CITY OF ALBUQUERQUE

**RE: Starbucks
4301 San Mateo Blvd. NE
Request Permanent C.O. – Accepted
Engineers Stamp Date 2/9/15 (G17D006C)
Certification Dated 10/23/15**

**RE: Starbucks
4301 San Mateo Blvd. NE
Request Permanent C.O. – Not Accepted
Engineers Stamp Date 2/9/15 (G17D006C)
Certification Dated 10/23/15**

GRADING & DRAINAGE PLAN

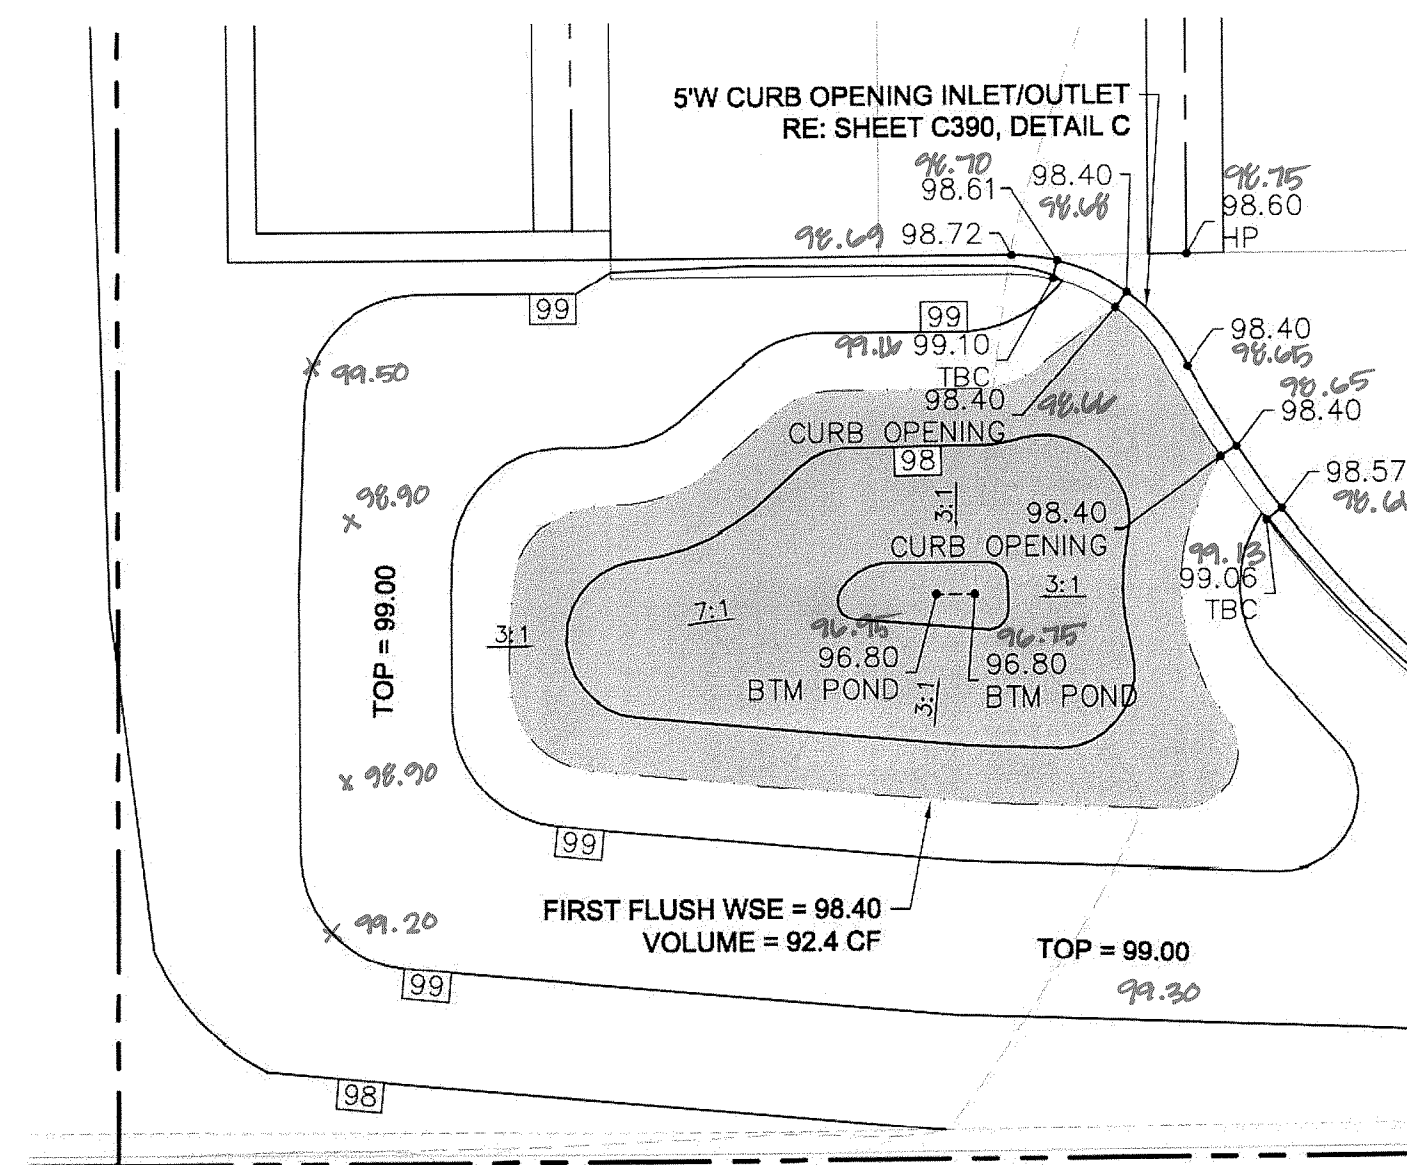
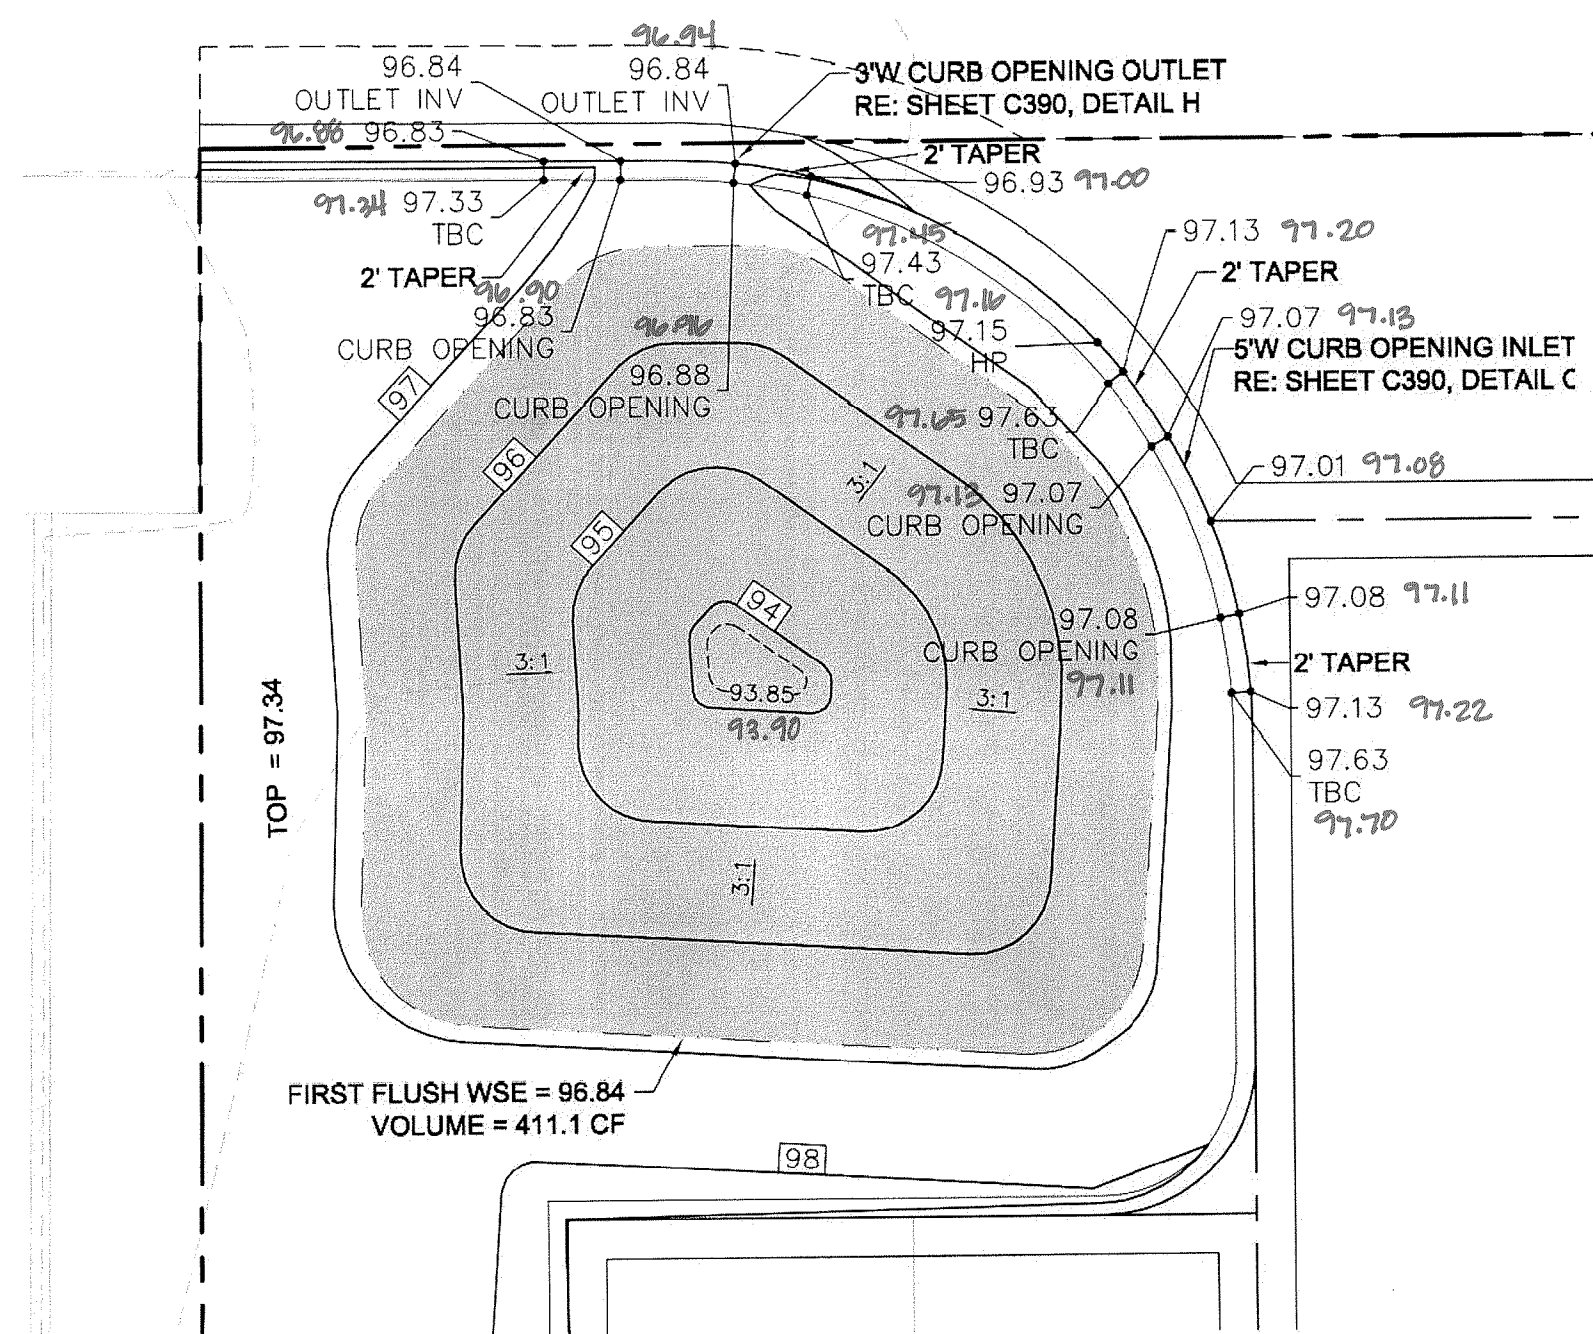
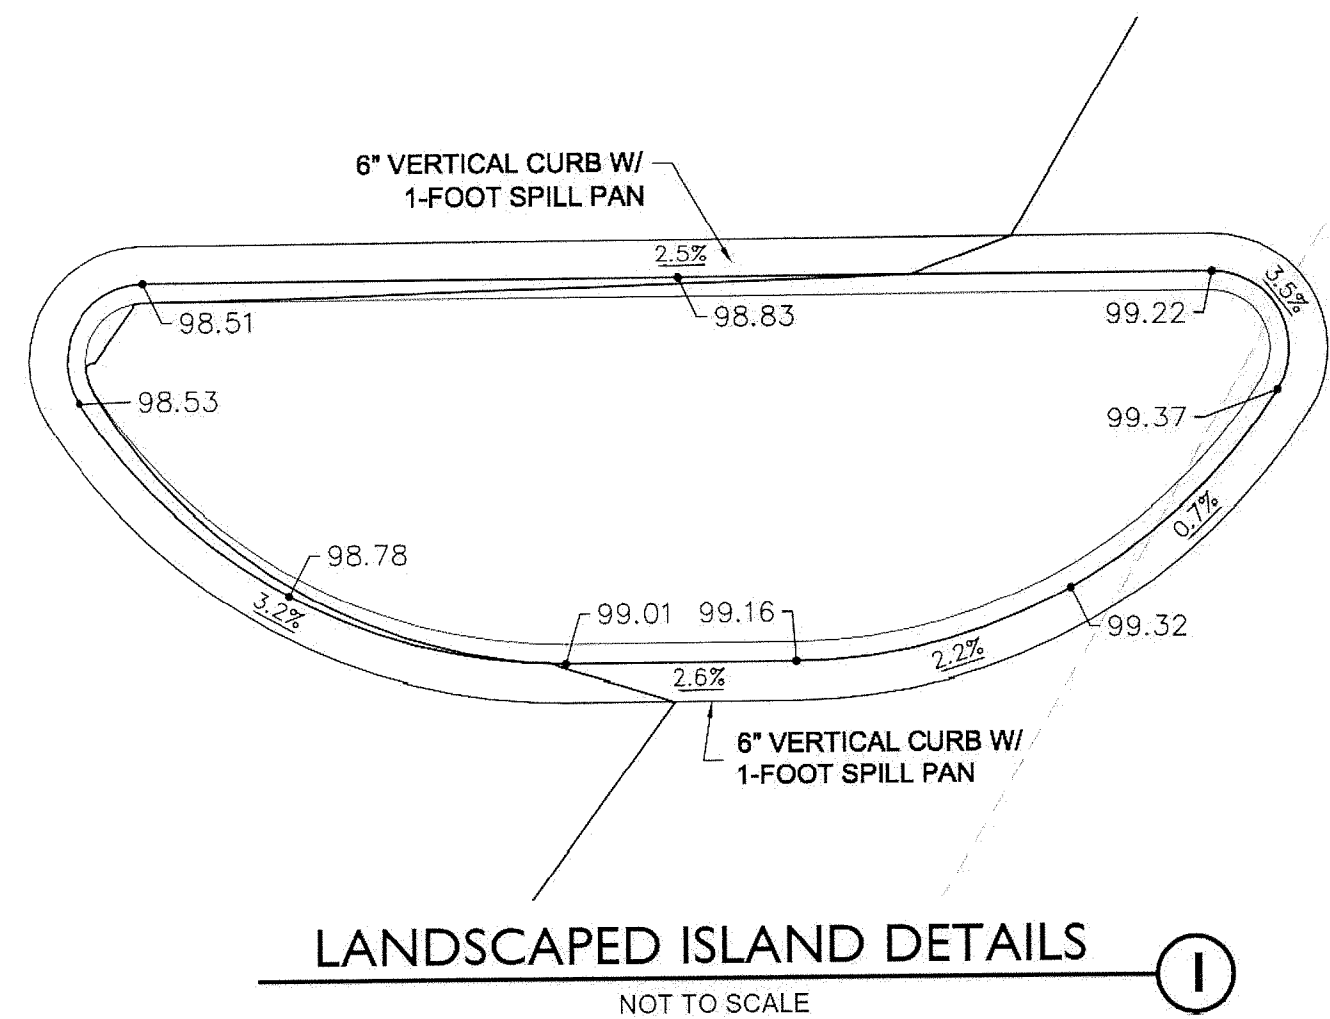
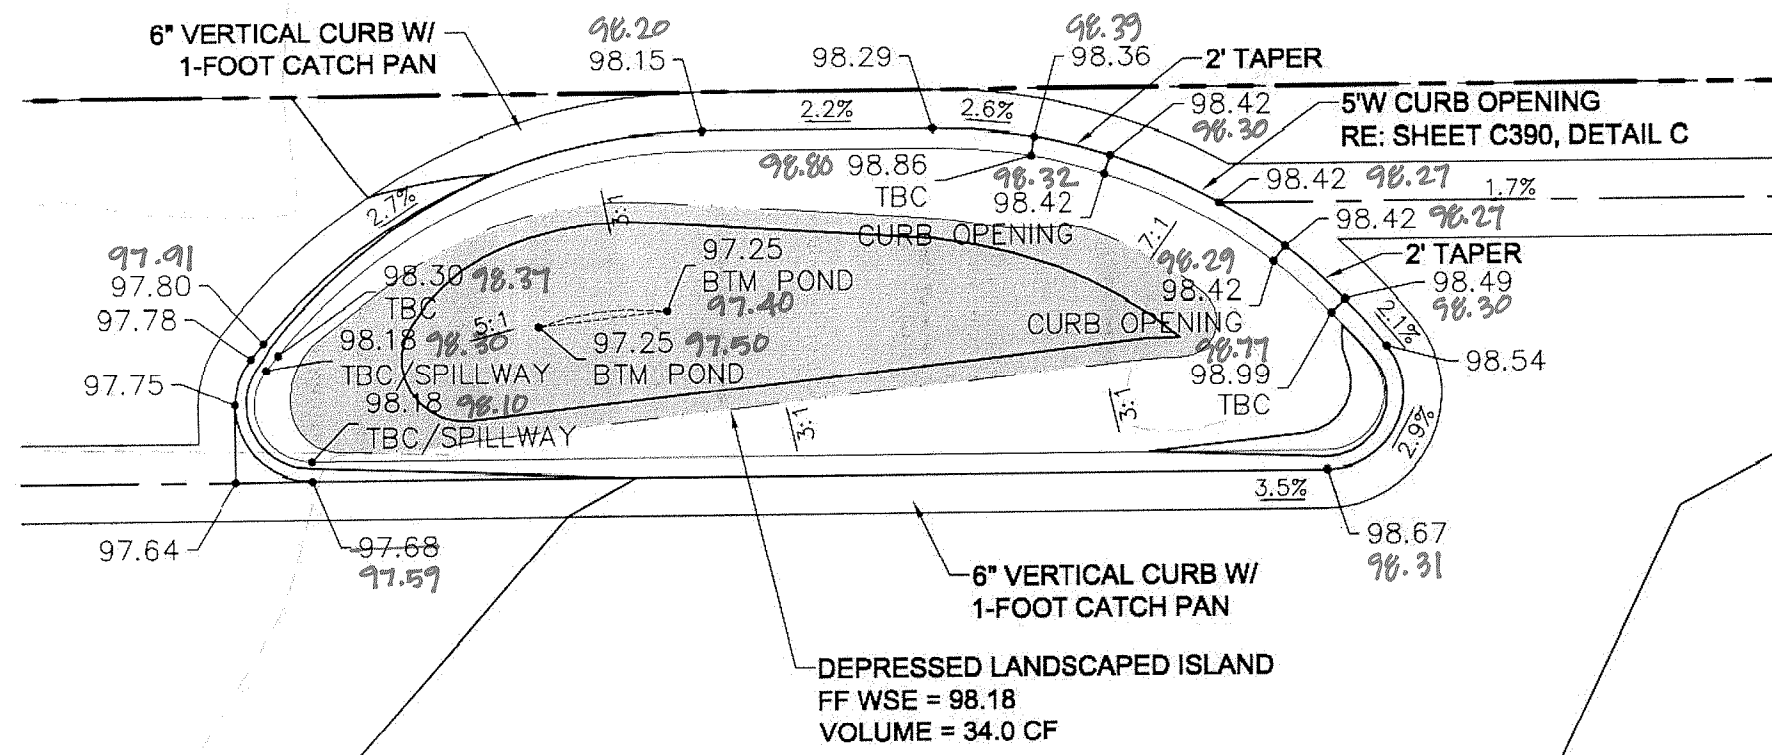
- The concrete sidewalk culvert does not have the steel plate top.
- The 2' wide concrete pan from the concrete sidewalk culvert following thru behind the north parking area is missing.
- The 6" curb opening on the west end of the building is missing.
- Justify this course of action or follow the plan which was approved.

- The concrete sidewalk culvert is not within a paved pedestrian access, but is rather within a landscape area. Therefore pedestrian access across the top of the culvert by use of a steel plate is unnecessary.
- Based on the as-built field shots it appears there is adequate fall from the outlet of the sidewalk culvert across the adjacent downstream parking area. Therefore the 2' wide pan is unnecessary.
- As clarified in separate correspondence, the city's concern is in regard to the 6" curb opening on the "east" end of the building. Inclusion of a 6" curb opening may have provided additional drainage benefits to the adjacent landscape area; however, the lack of such an opening serving a relatively small tributary area should not significantly alter the overall design intent of the grading and drainage aspects of the project as described on the approved plan(s).

As the compliance language on the As-Built Sheet C301, stamped 10/23/15 indicates; these deviations from the grading and drainage design described on the approved plan(s) represent discrepancies which are minor in nature and/or should impact maintenance of the property rather than the overall drainage design intent.
